CLAREMONT BUSINESS PARK 2 FILING NO. 2

CONSTRUCTION PLANS

EL PASO COUNTY FILE NO. VR233

TITLE SHEET

**EL JEFE HEIGHTS  
STA 1+00.00 - 7+95.49**

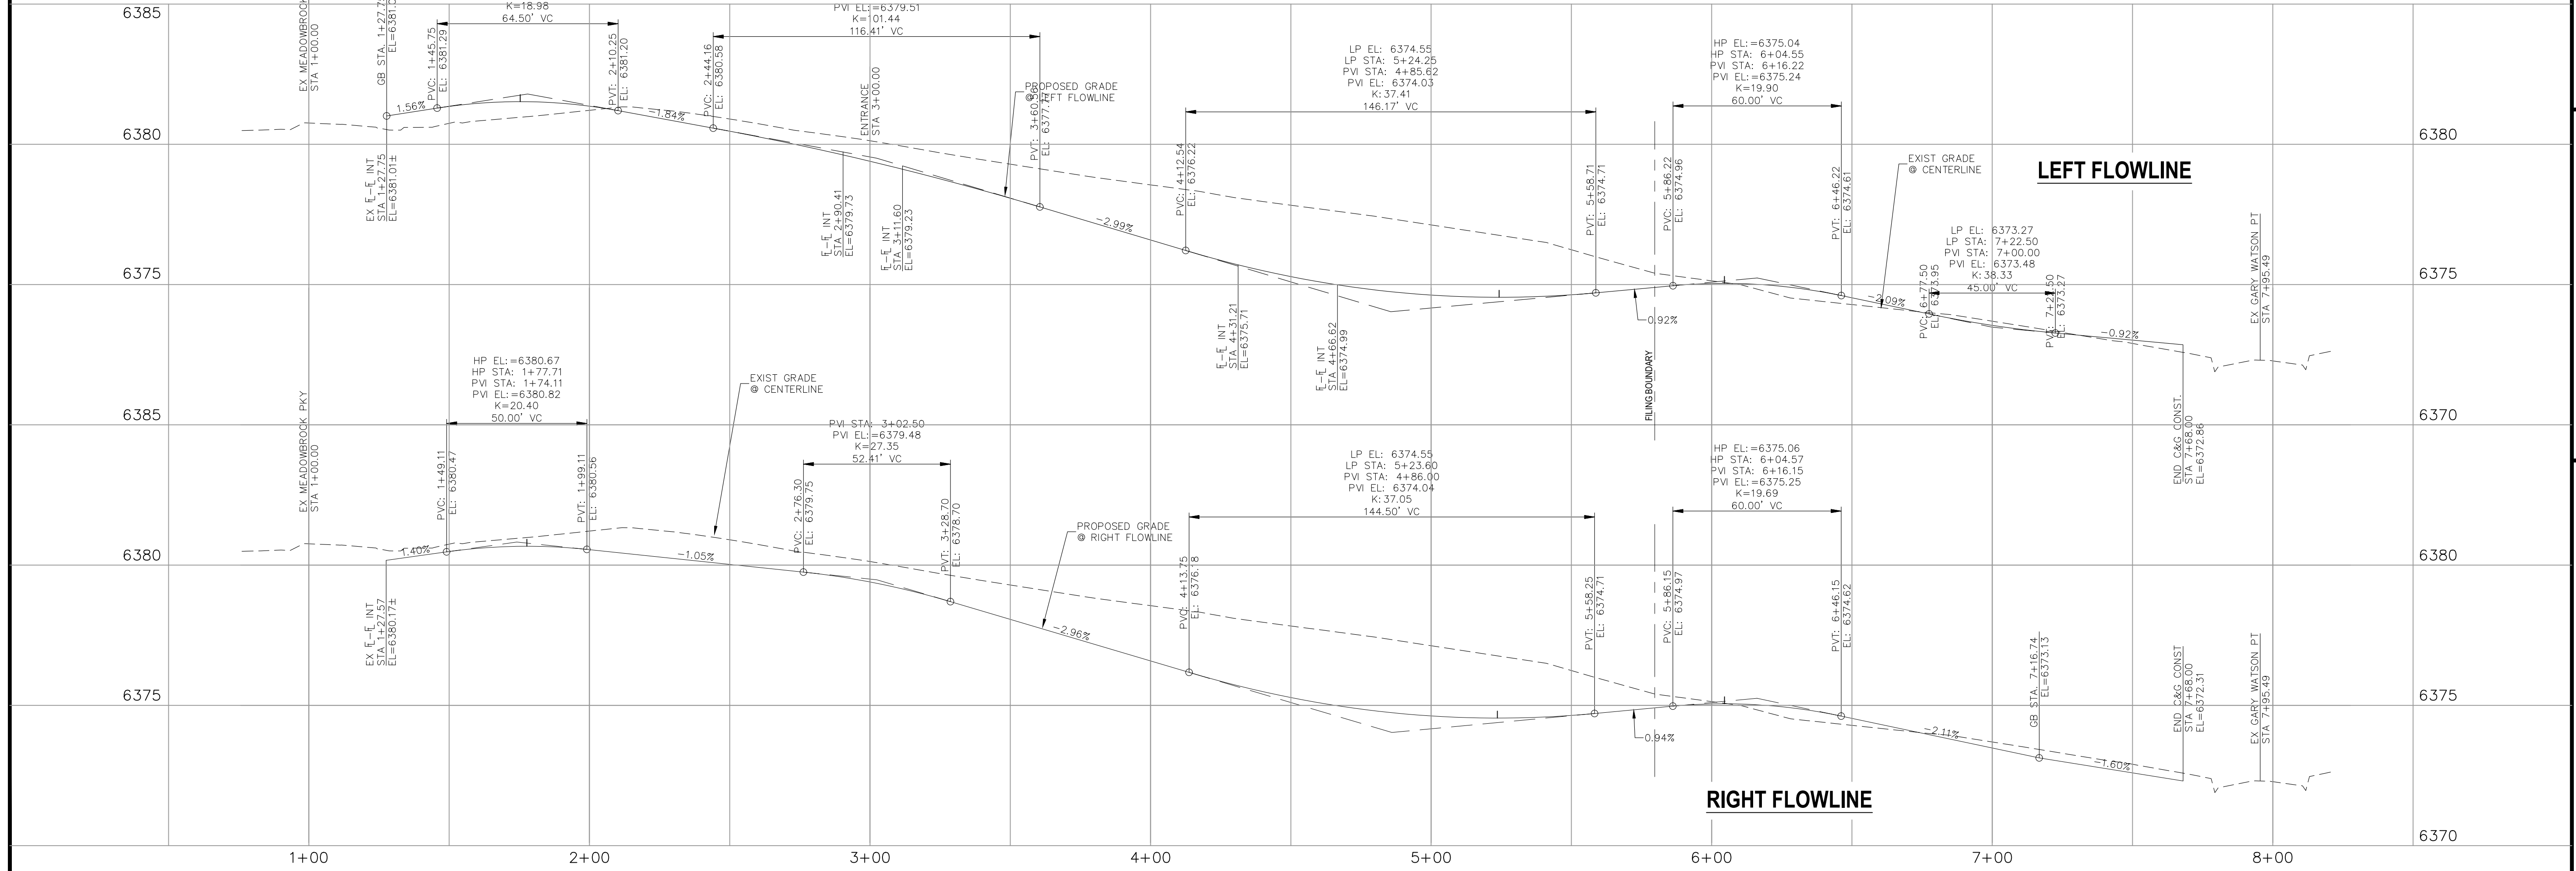
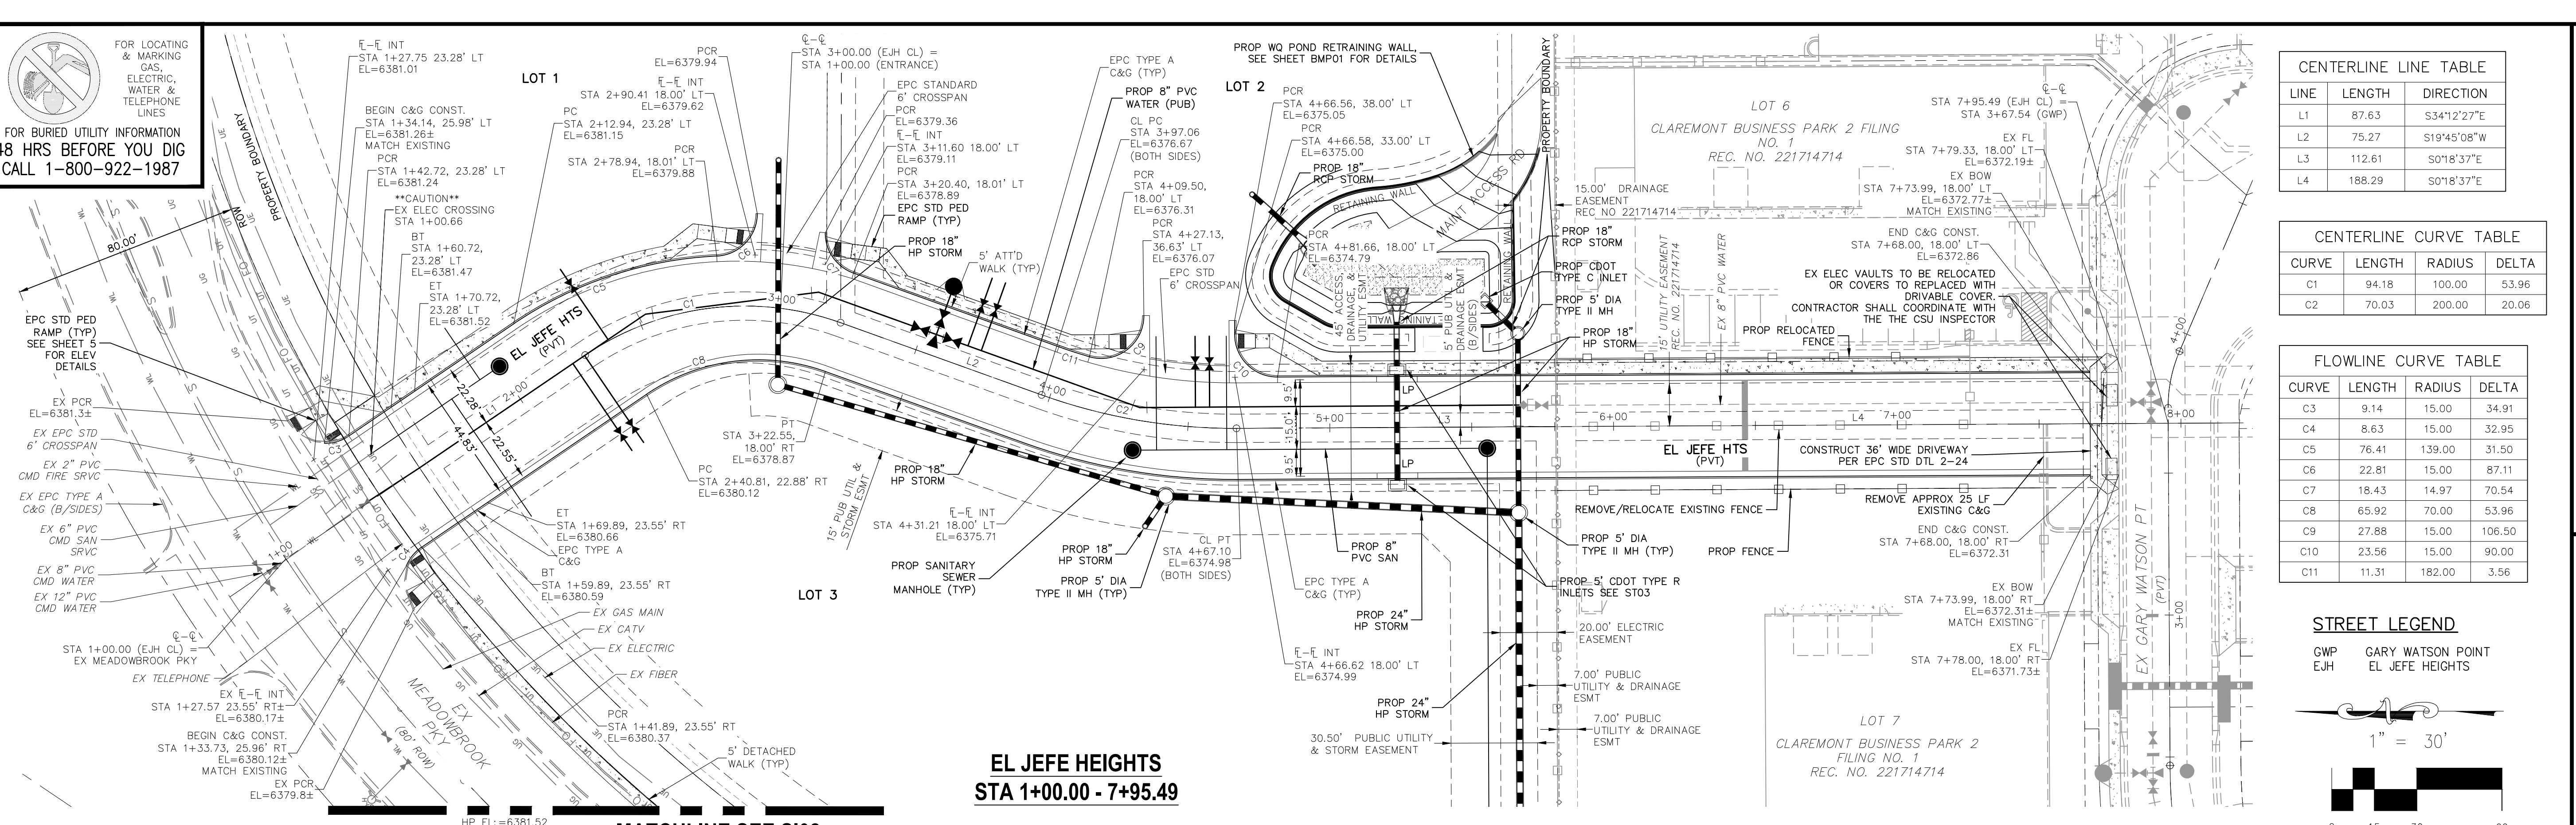
Label if a stub cap is proposed for all similar pipe runs.

Label if existing or proposed.

Show & label proposed retaining wall

Reference EPC standard driveway detail

Show existing and proposed utilities

STREET PLANS TYPICALLY DO NOT SHOW UTILITIES IN THE PROFILE VIEW BECAUSE THE ALIGNMENT OF THE STREET PROFILES IN RELATION TO THE UTILITY PROFILES ARE NOT ONE IN THE SAME, AND THE THEREFORE, IF SHOWN, THE ELEVATIONS TO ONE ANOTHER ARE NOT RELEVANT. THE STREET PROFILES ARE LEFT, RIGHT CURB PROFILES, AND UTILITIES ARE IN THE ROADWAY. THE FINAL SURFACE WOULD NOT BE AN ACCURATE INTERPRETATION OF THE SURFACE ELEVATIONS AT THE UTILITY ALIGNMENT. THE UTILITY PLAN(S) PROFILES SHOW THE PIPE AND THE PROPOSED AND EXISTING SURFACES AT THE ACTUAL ROADWAY SURFACE

NOT ONLY THAT BUT SHOWING UTILITIES WITH THE STREET PROFILES IS CUMBERSOME AND CONFUSING AND MAKES OBTAINING PROBLEMATIC AND A POTENTIAL FOR ERROR WHEN SHOWING THE SAME DATA WITHIN TWO SEPARATE TYPES OF CONSTRUCTIONS PLANS. ADDING THE UTILITIES IN THE PROFILE TAKES AWAY FROM THE PURPOSE OF THE "STREET" PLANS. WE RESPECTFULLY REQUEST THE COMMENT BE ELIMINATED.

**STORM 1 LAT-4 (PRIVATE)**  
STA 1+00.00 TO STA 1+78.99

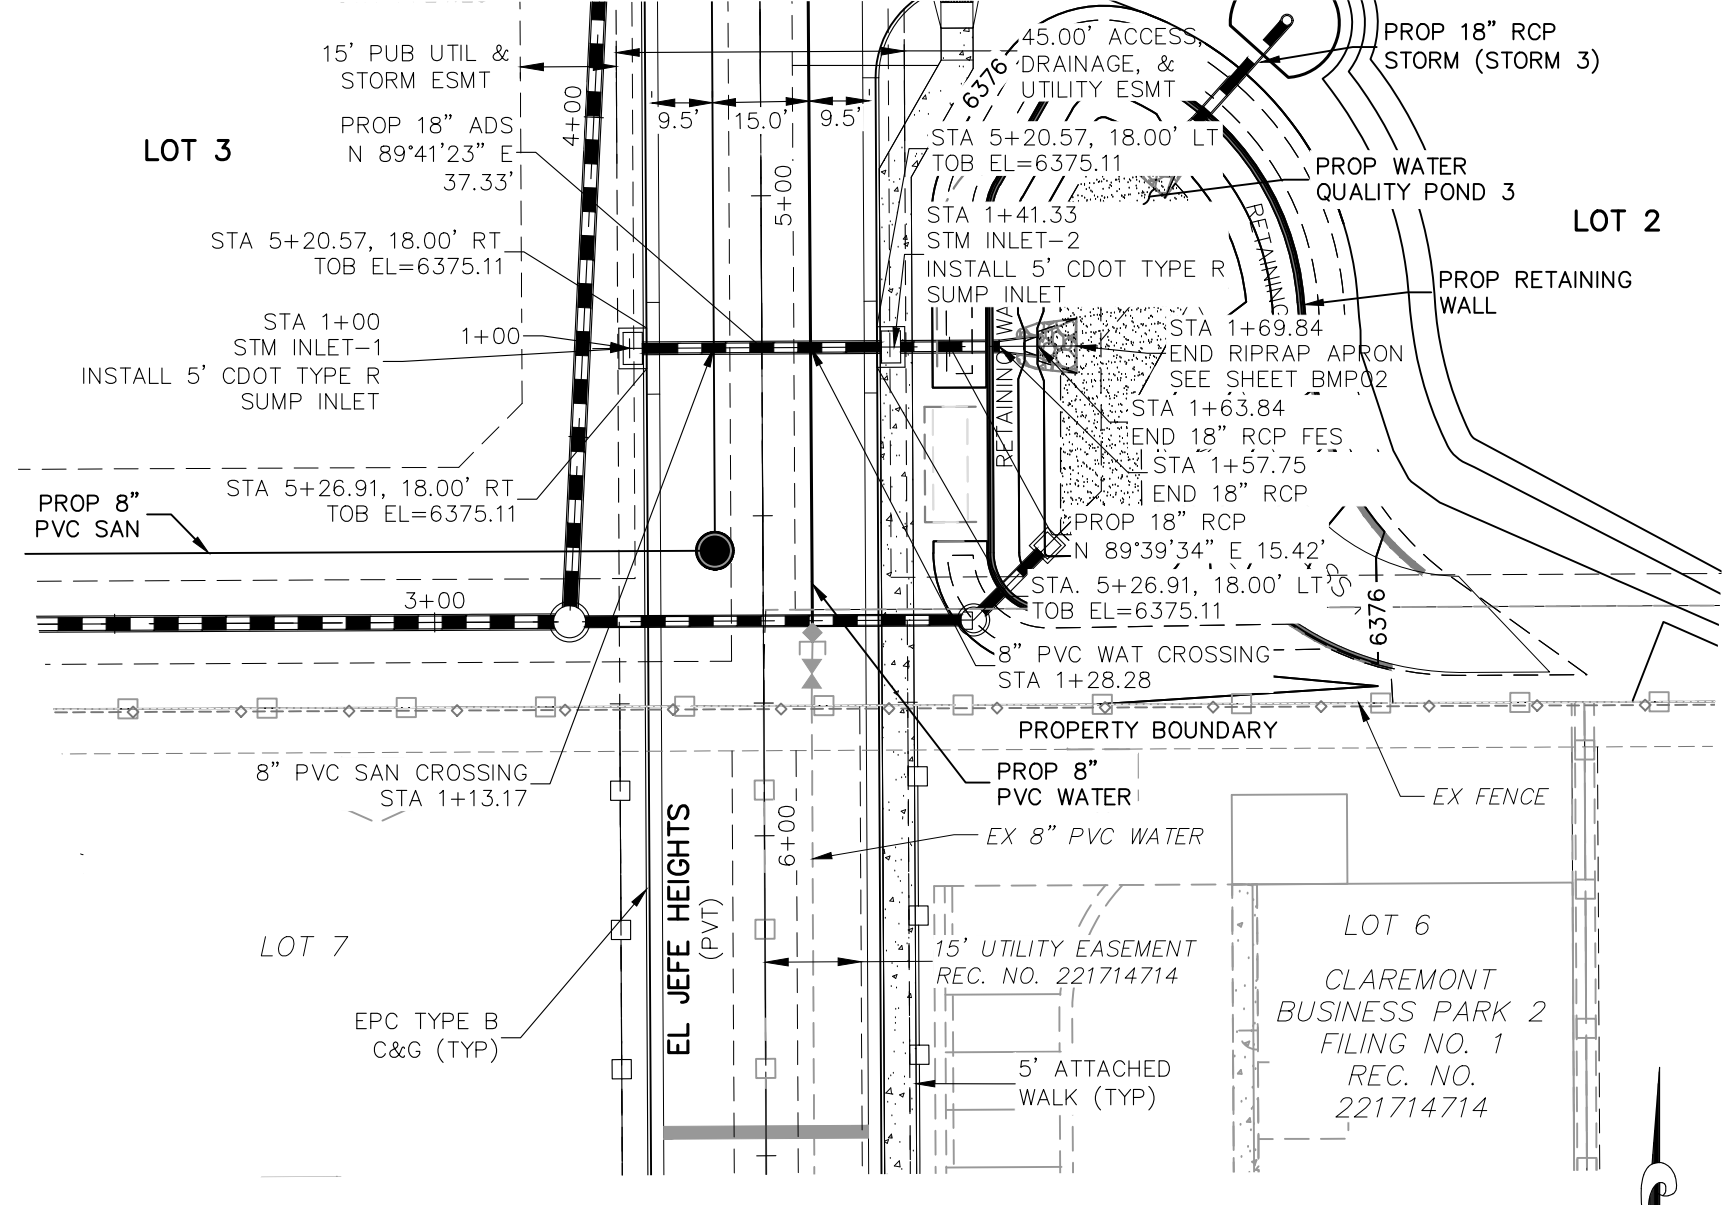
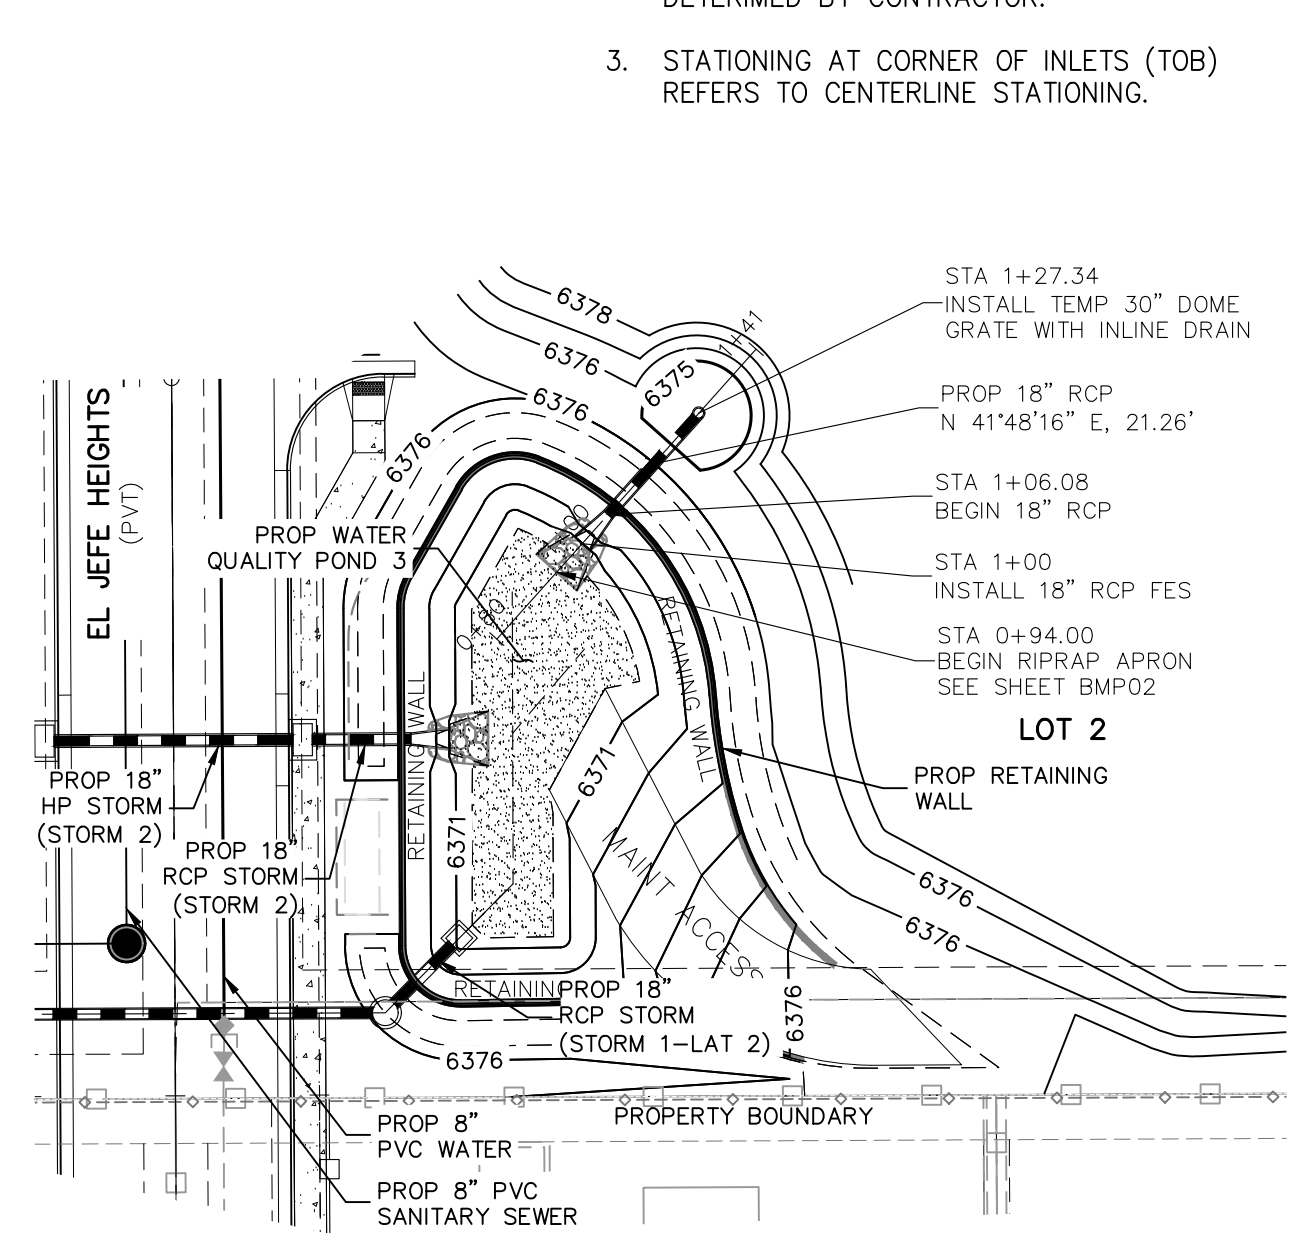
Reference sheet for apron detail
